Subject: LU/81/20/L

### *Listed building consent to replace windows*

FLAT 5, 16 SOUTH TERRACE

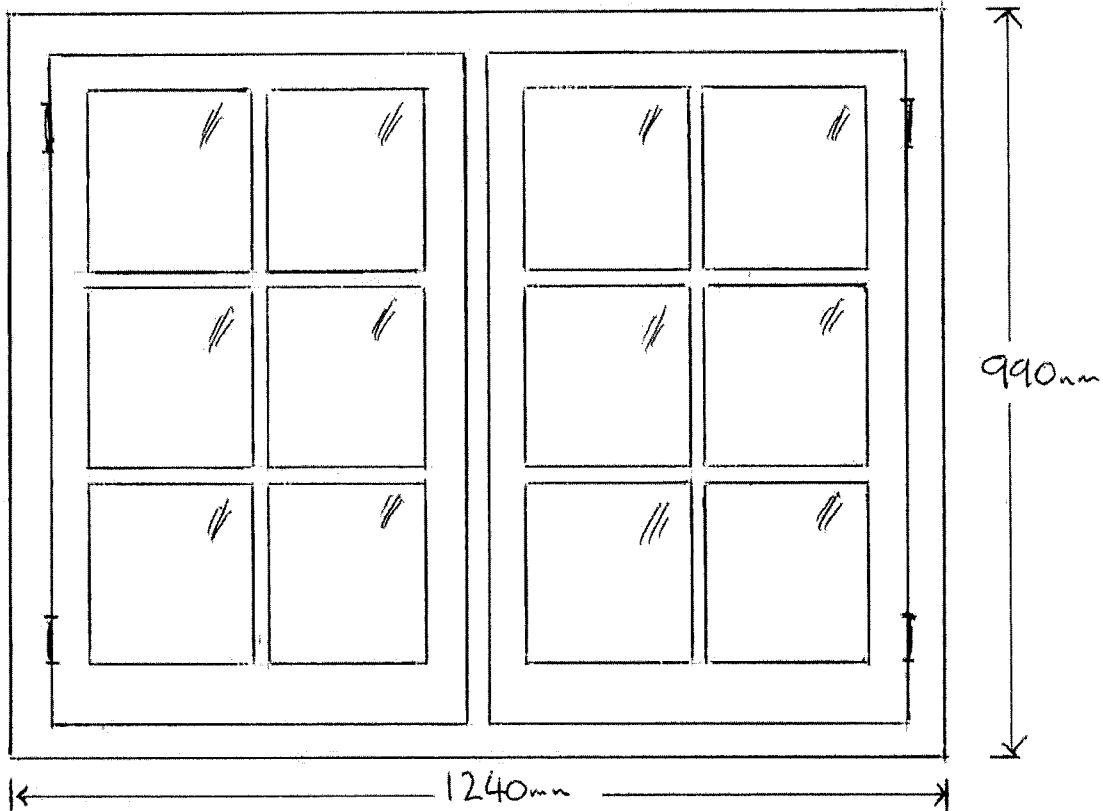
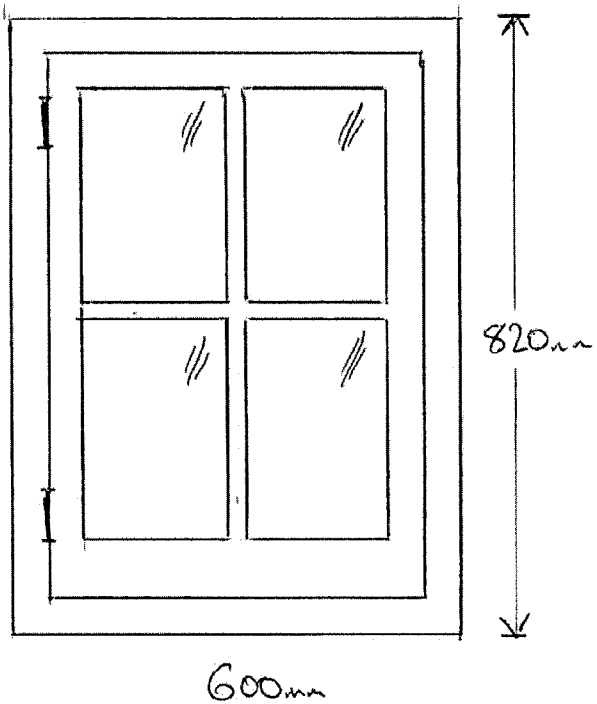
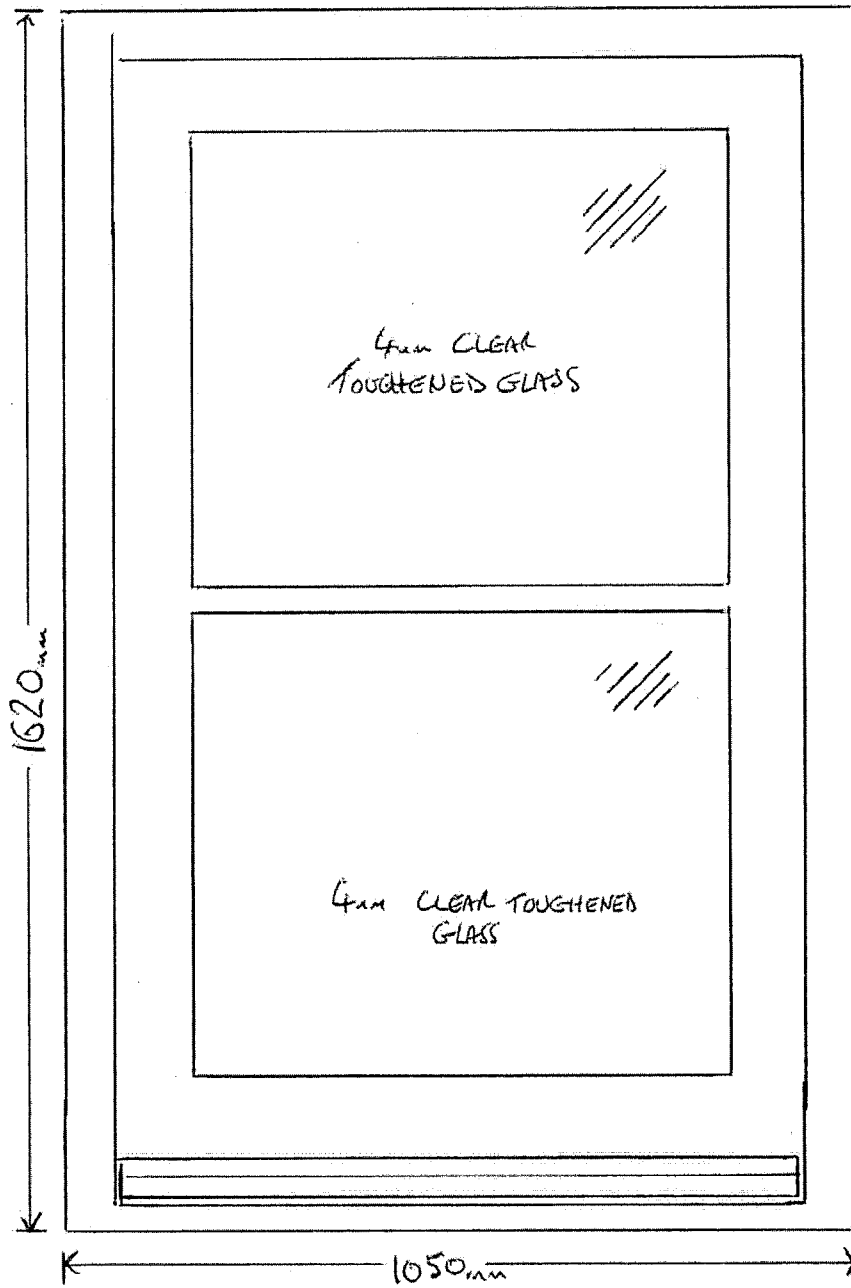
The proposal relates to two replacement windows and a door. It is noted that the existing windows and doors are constructed from inappropriate materials, and their removal is supported. The replacement windows are to be constructed from wood, which is an enhancement to both the building and conservation area. It is suggested that they be painted to match those in the rest of the building.
